Construction of 1 No. new two storey house (resubmission following A/31/19/PL). This application is a Departure from the Development Plan & affects a Public Right of Way.

Land between Ashurst and Badgers Ham Manor Way Angmering

Thank you for your internet representation made on 13th June 2019 which has been recorded as **'an objection'** with the comments as follows:

Site Location Plan (1:1250)

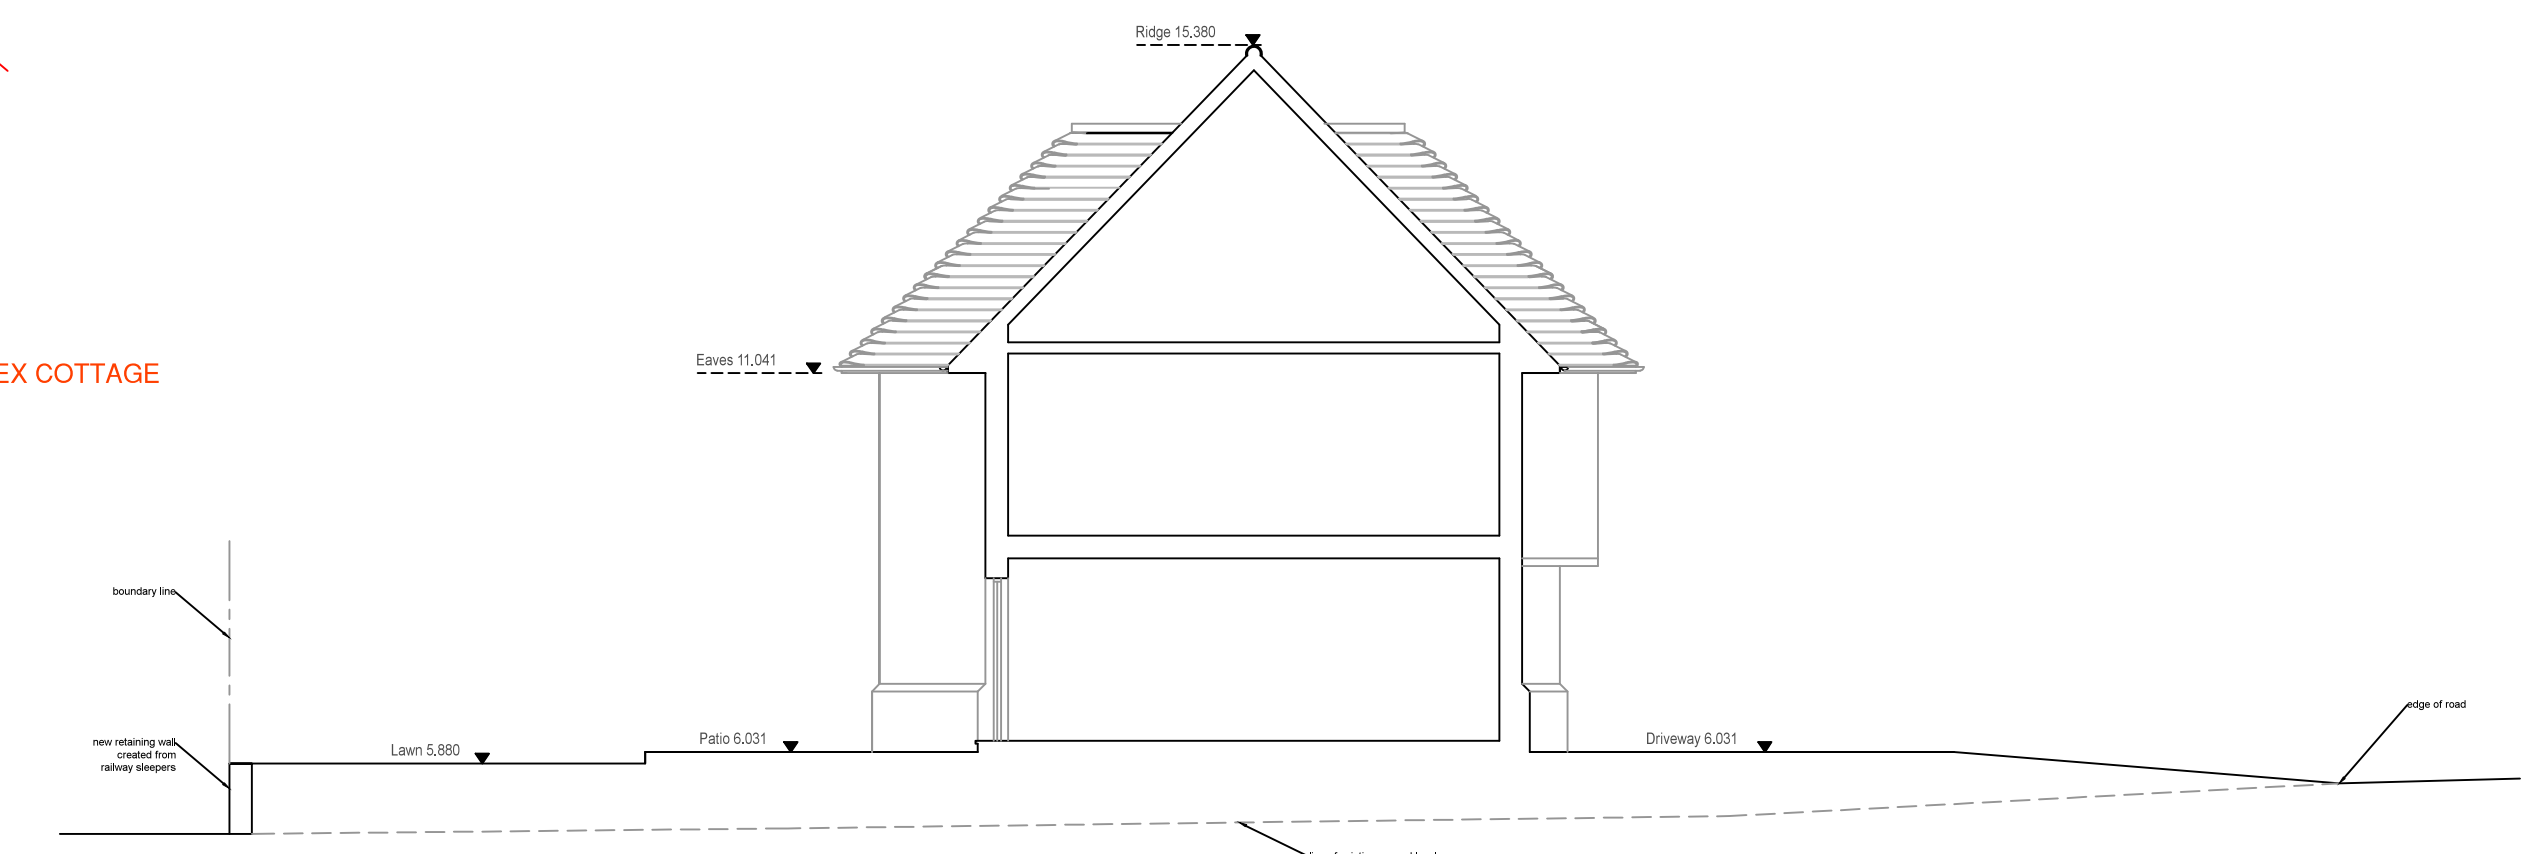
As shown on the submitted plan drawing, drawing number 1202.02.c, the proposed property is positioned a long way forward of the historical build line which can be seen from aerial photo's on Google map. On both sides of Ham Manor Way there is a defined line where properties are not built in front of. This again demonstrates the property is too big for the plot size whilst trying to gain a back garden.

Client: Mr & Mrs Jones
Project Address:
Land at the 9th Tee
Ham Manor Way
Angmering
Drawing Title:
Proposed Plans, Elevations and Street
Scene Elevation
Drawing Number: 1202.01.d
Scale: As stated printed @ A1
Date: 06/02/2019

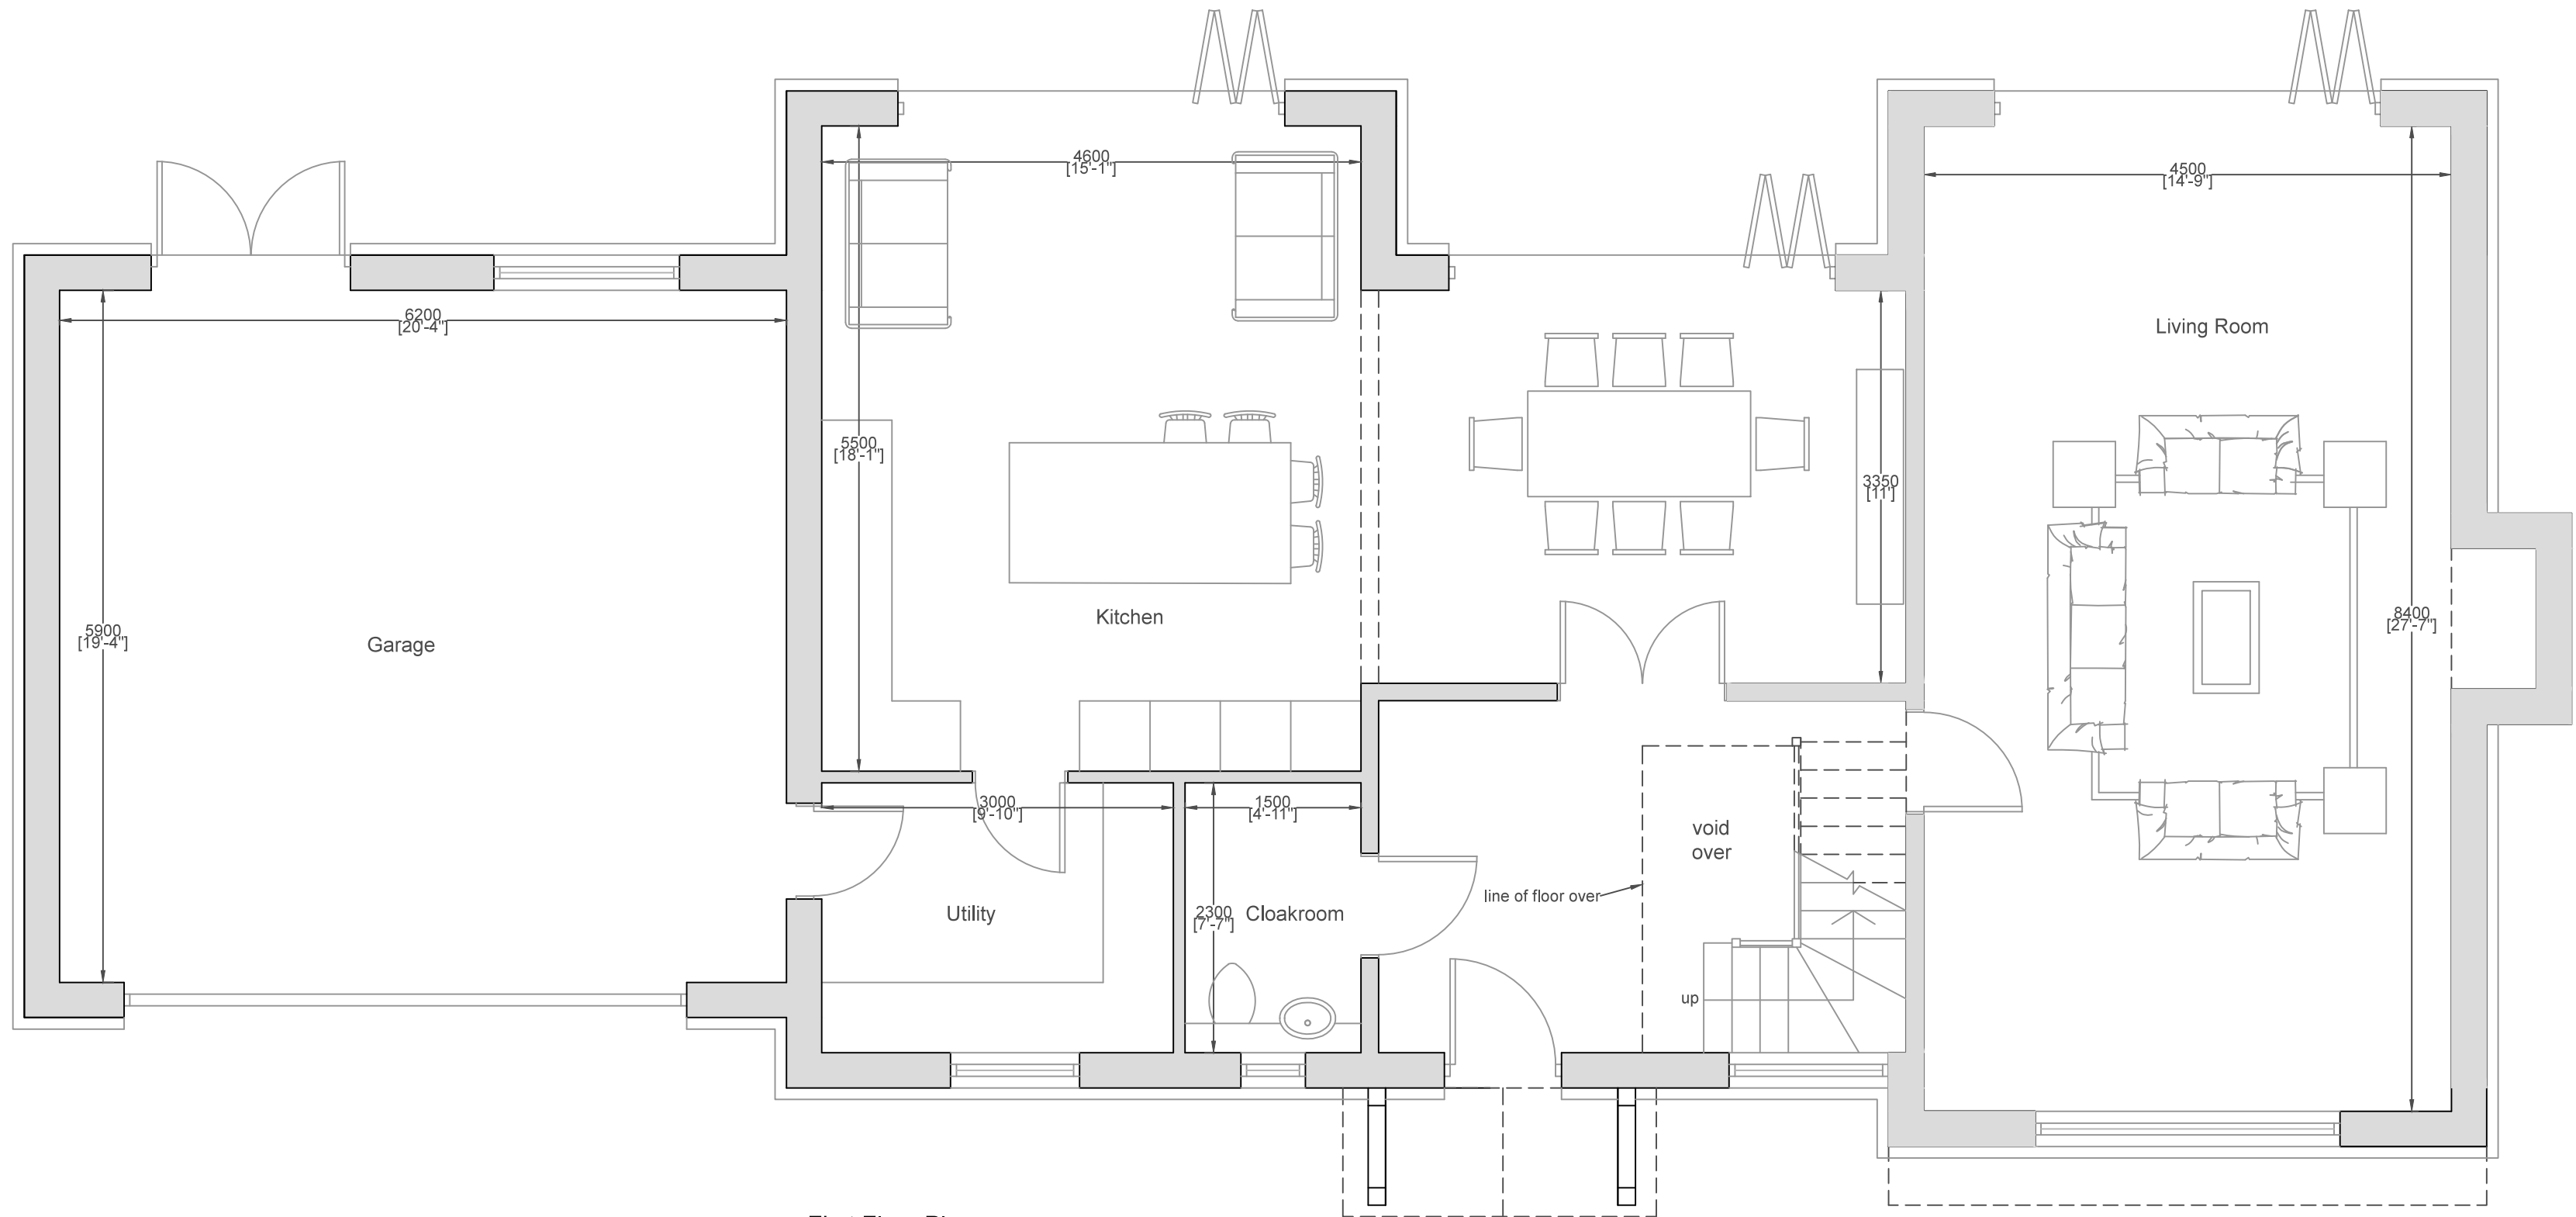
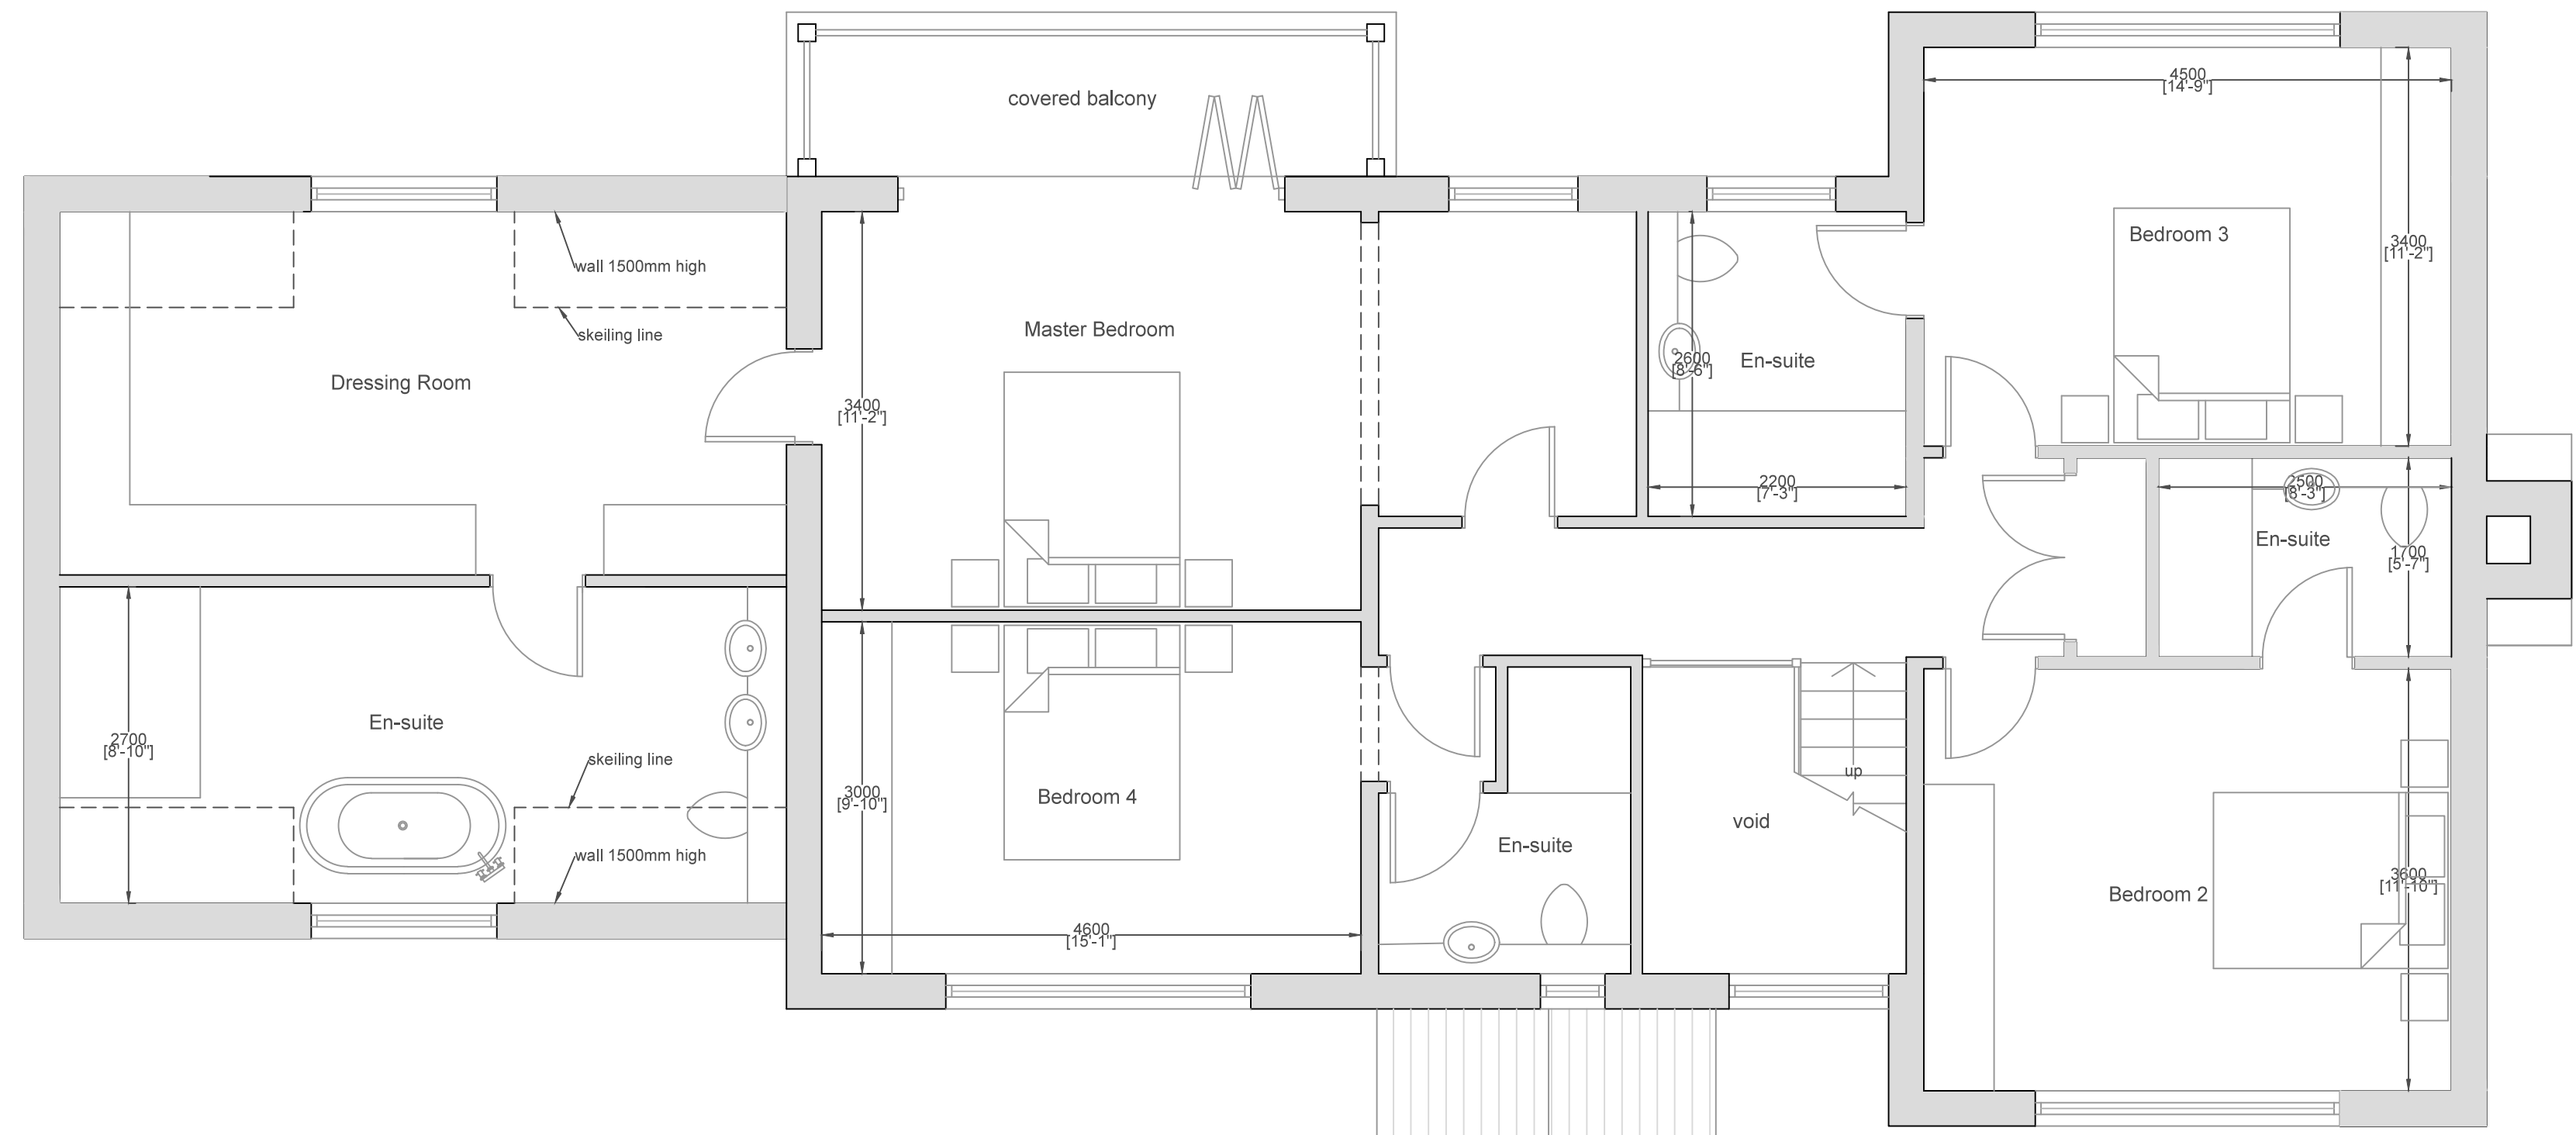
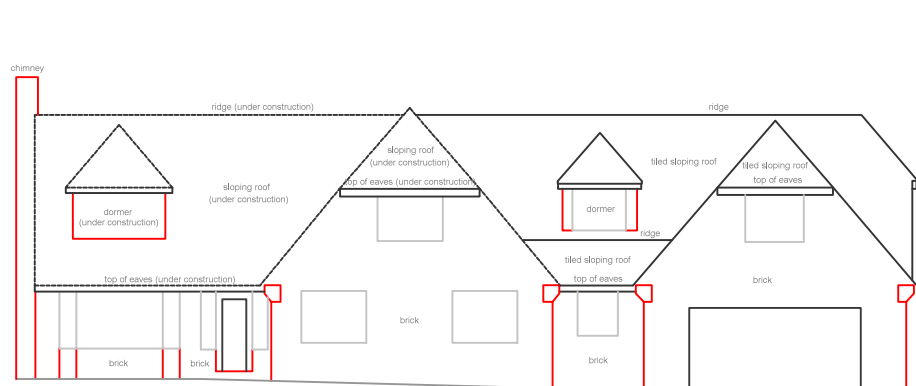
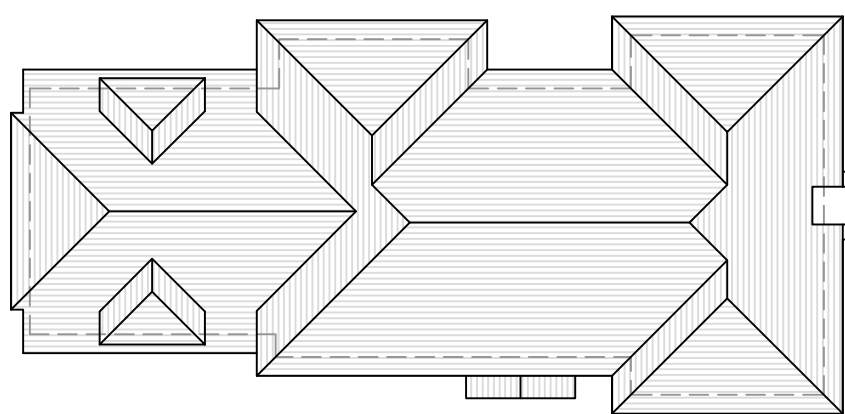
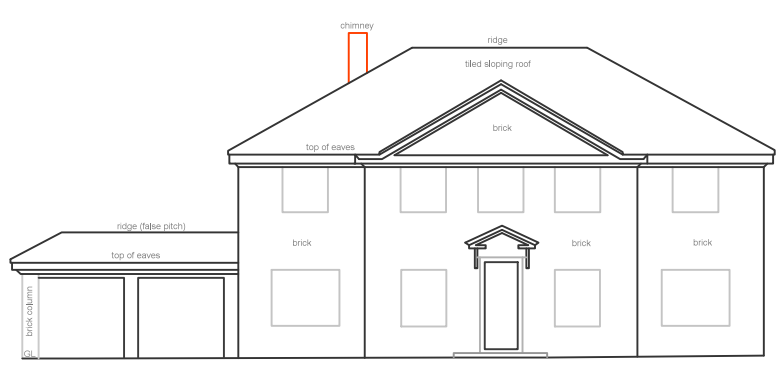
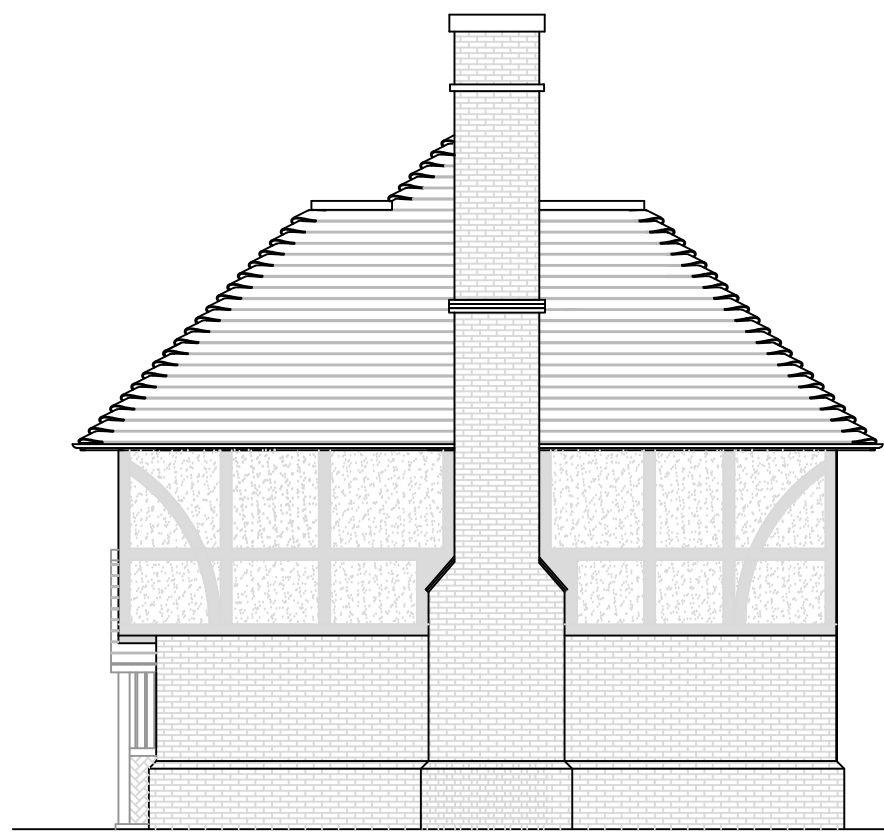
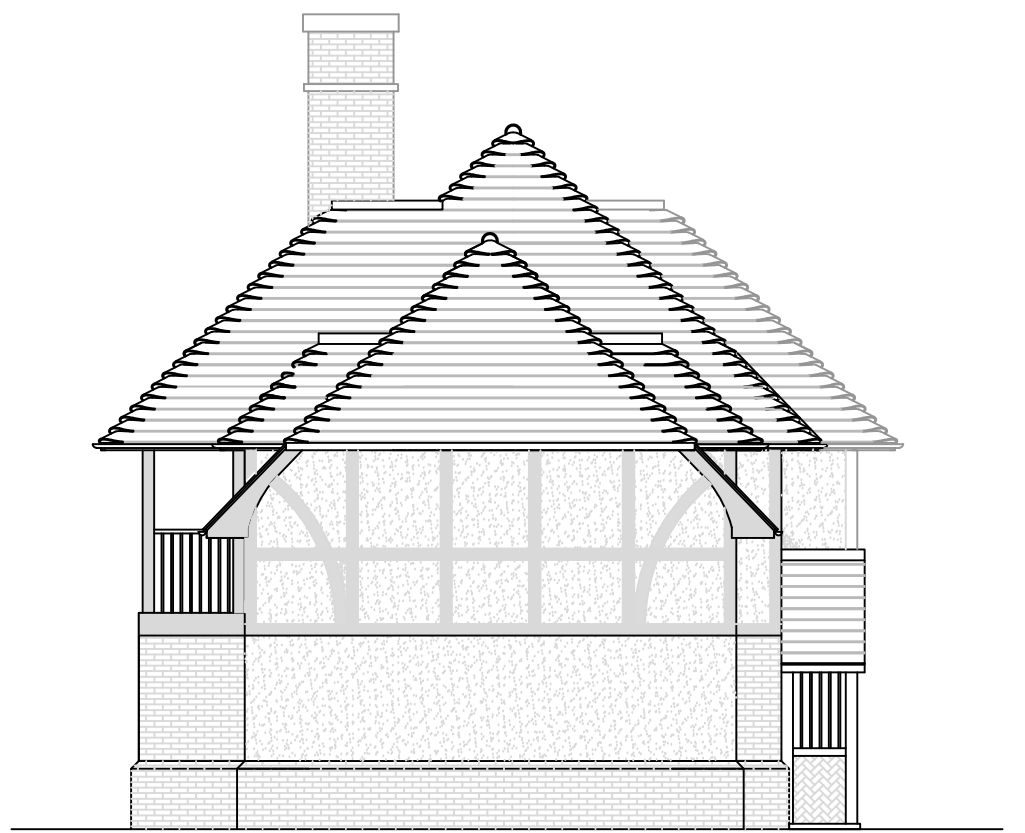
In the same document under NEIGHBOURHOOD CONSIDERATION it states there are no side facing first floor windows, if planning is allowed then this should be enforced on the permission for both first floor and ground floor to prevent overlooking neighbours to the SW and NE with a material change later.
